DRAINAGE REPORT
FOR
RIO VOLCAN APARTMENTS
(Ladera Apartments)

**RE: RIO VOLCAN/LADERA APARTMENTS (H10-D16) DRAINAGE REPORT
SUBMITTAL FOR SITE DEVELOPMENT PLAN FOR BUILDING PERMIT AND
GRADING PERMIT APPROVAL. ENGINEER'S STAMP DATED 8-31-95.**

**RE: DRAINAGE REPORT FOR SITE DEVELOPMENT PLAN FOR PERMIT
APPROVAL AND GRADING PERMIT APPROVAL. LADERA APARTMENTS
(H10/D16). ENGINEER'S STAMP DATED 6-30-95.**

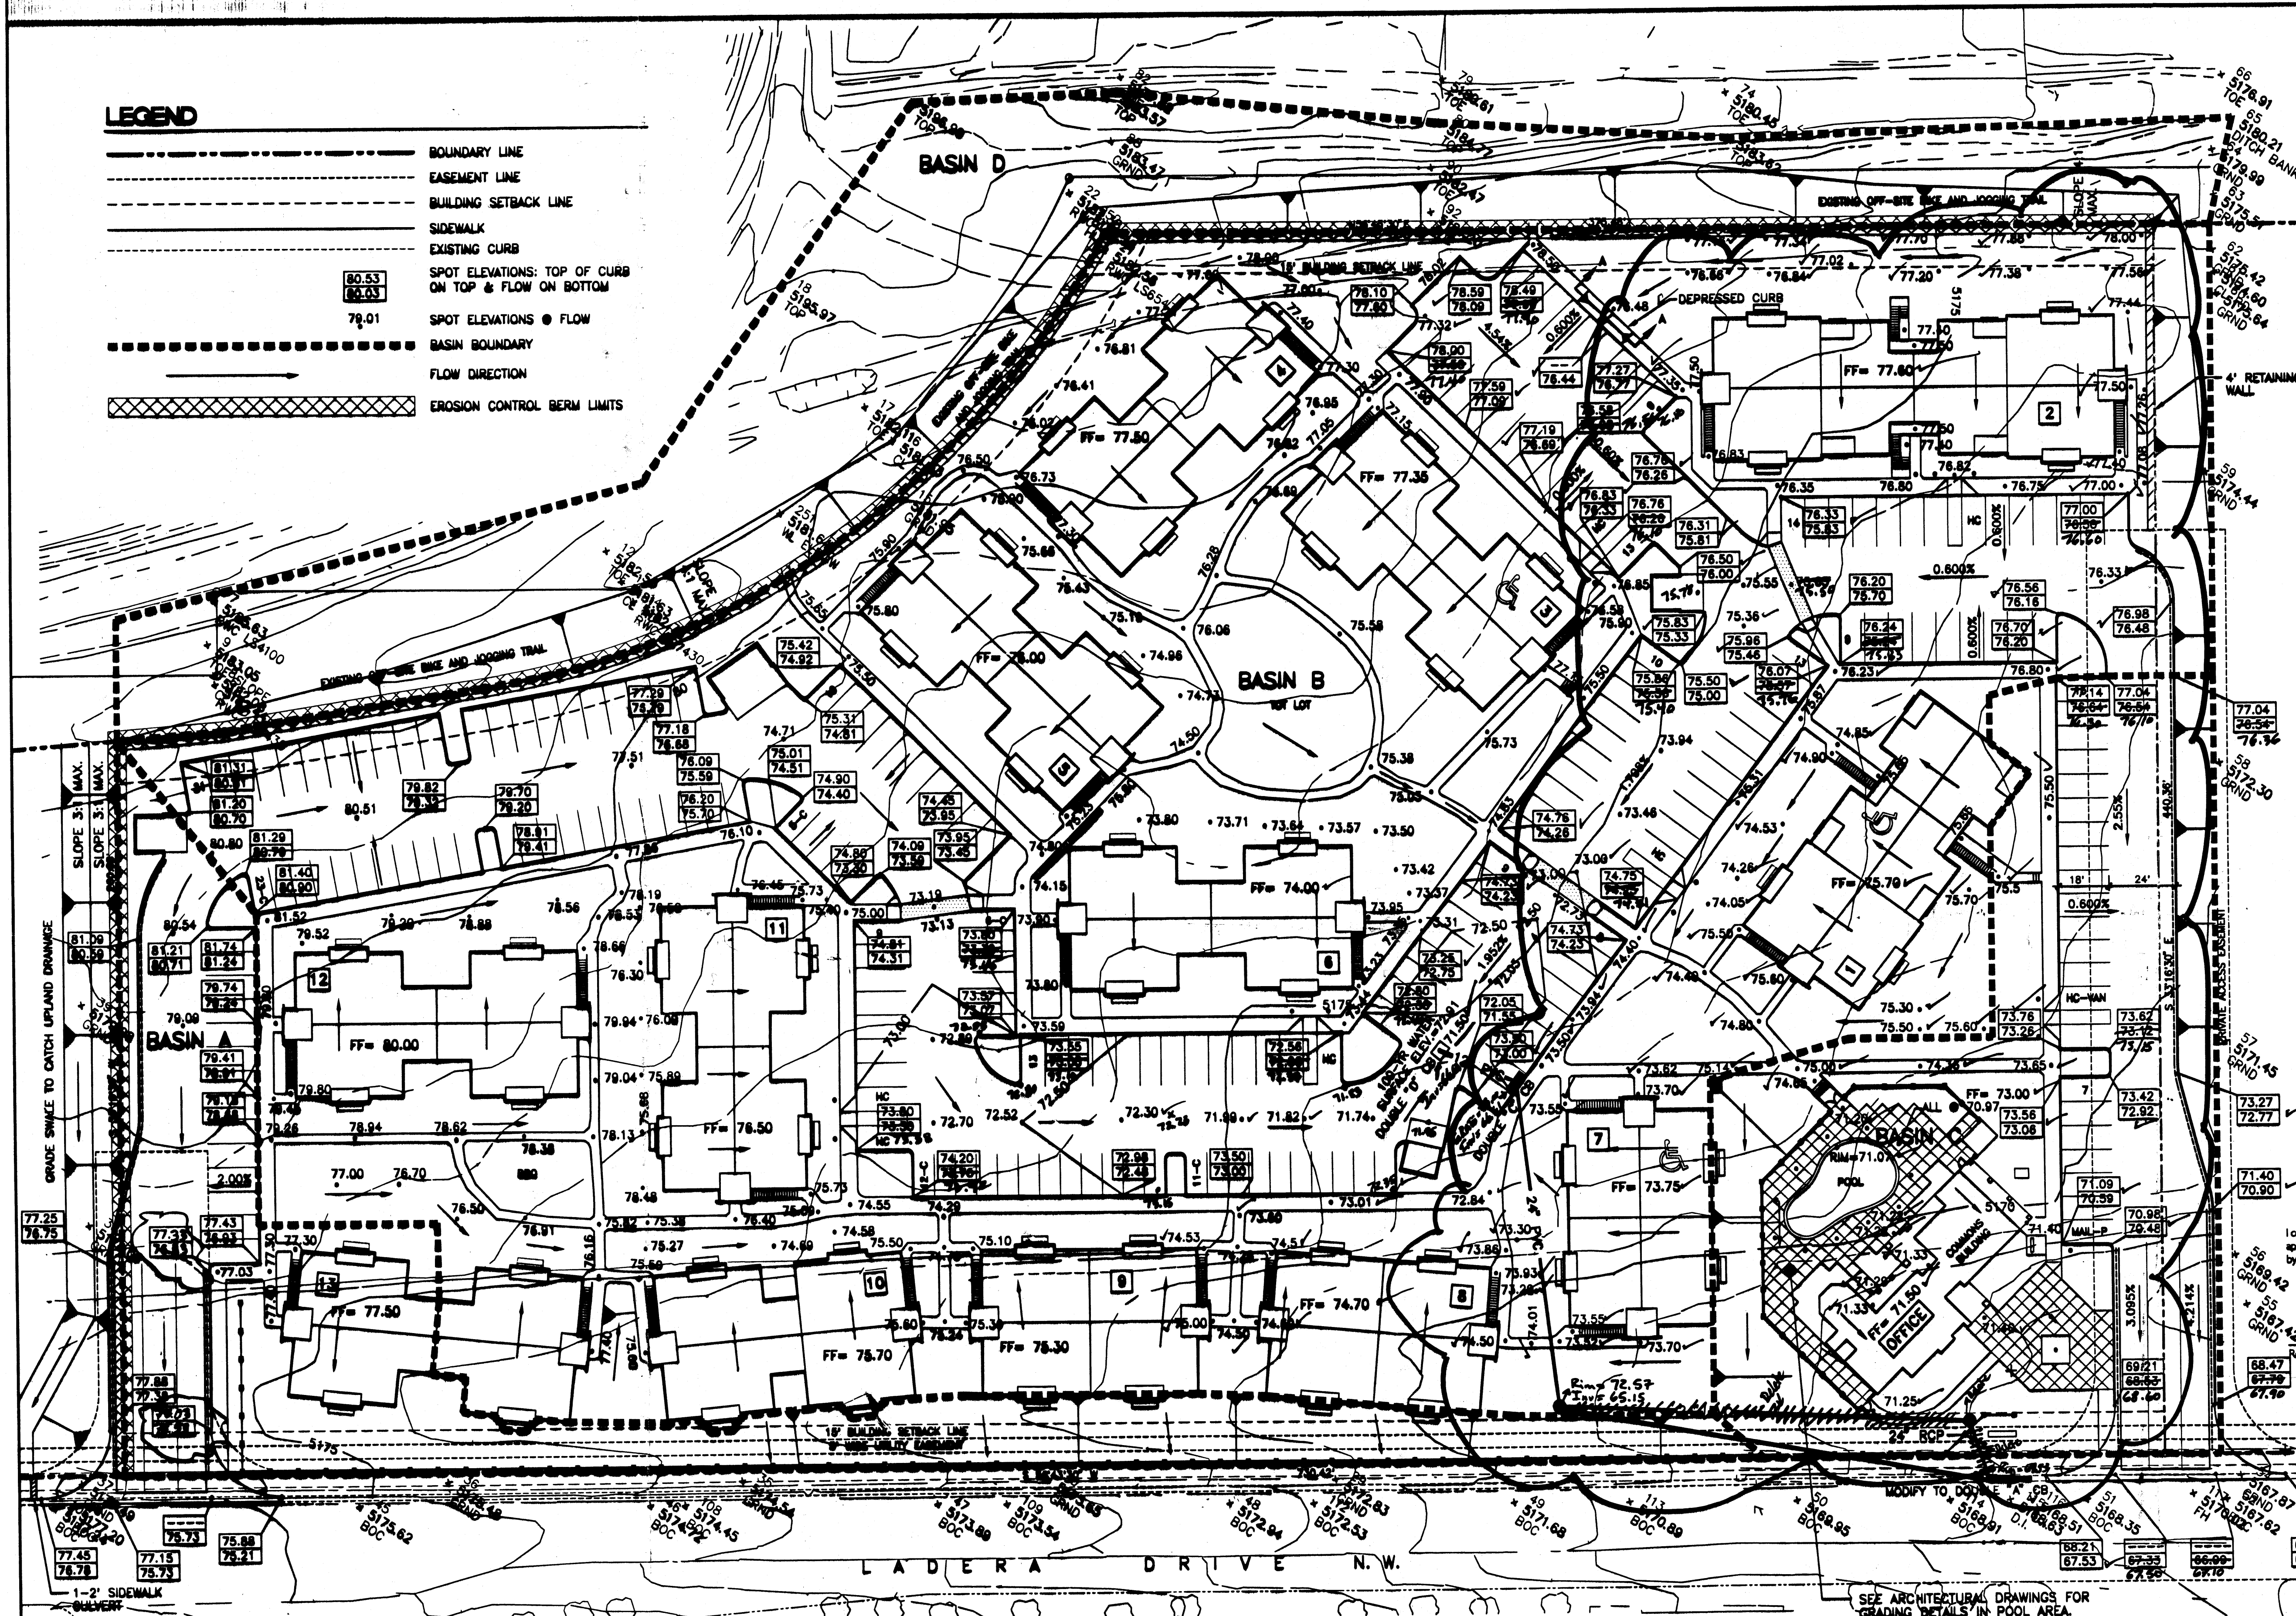
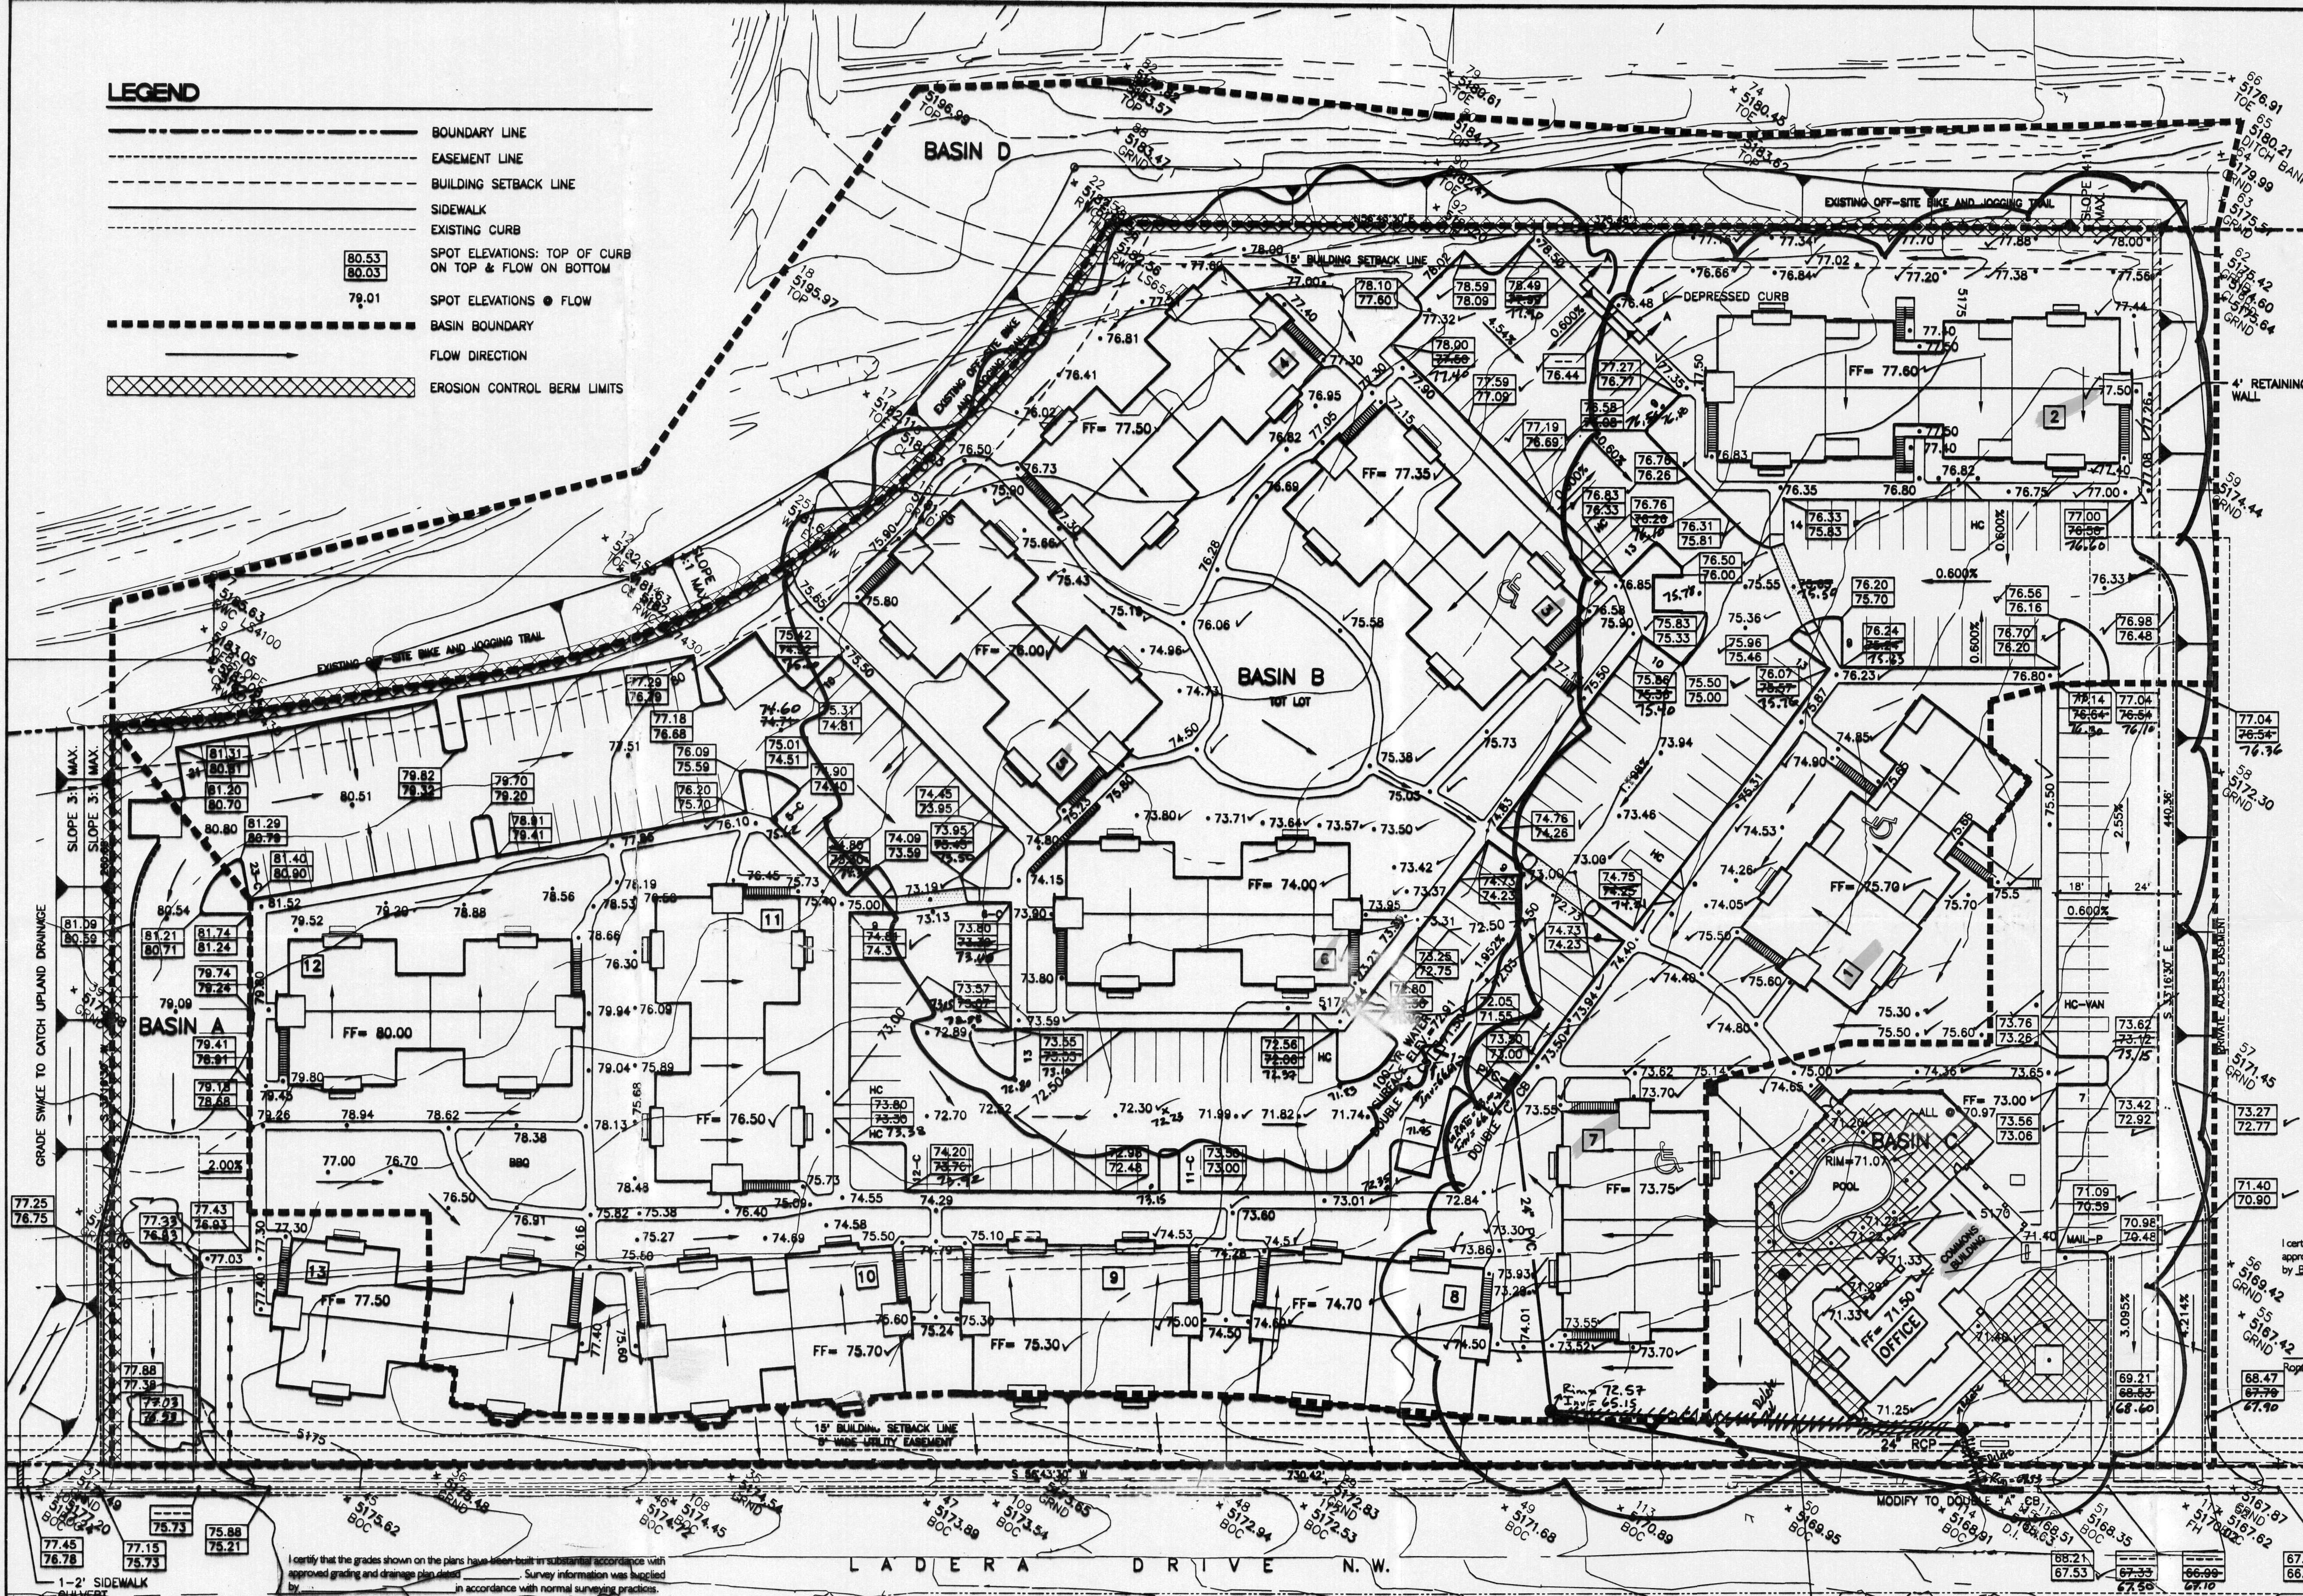
1. How do your proposed grades tie into adjacent properties? Show spots and contours a minimum of 25 feet beyond your property line. Will your development have any effect on AMAFCA's Right-of-Way?

2. After reviewing the drainage report you referenced by Isaacson & Arfman (H10/D13), I found that SAD No. 212 yields an allowable discharge rate of 2.28 cfs/acre. Your conclusions are based on an allowable discharge rate of 3.00 cfs/acre. The actual flow from your site is shown as 17.36 cfs, which is above the allowable. Note, pond depths greater than 18 inches require a safety fence.

3. Show location of temporary erosion berm. Show location of sideyard wall referenced in your drainage report under "Existing Conditions."
4. Whenever a private storm drain line is to connect to an existing storm inlet in the City's Right-of-Way, the SO-19 format must be used. This format can be found in the City of Albuquerque DPM section 22.7. I have enclosed a copy for your convenience. Please be sure to add the highlighted notes and City sign-off block.
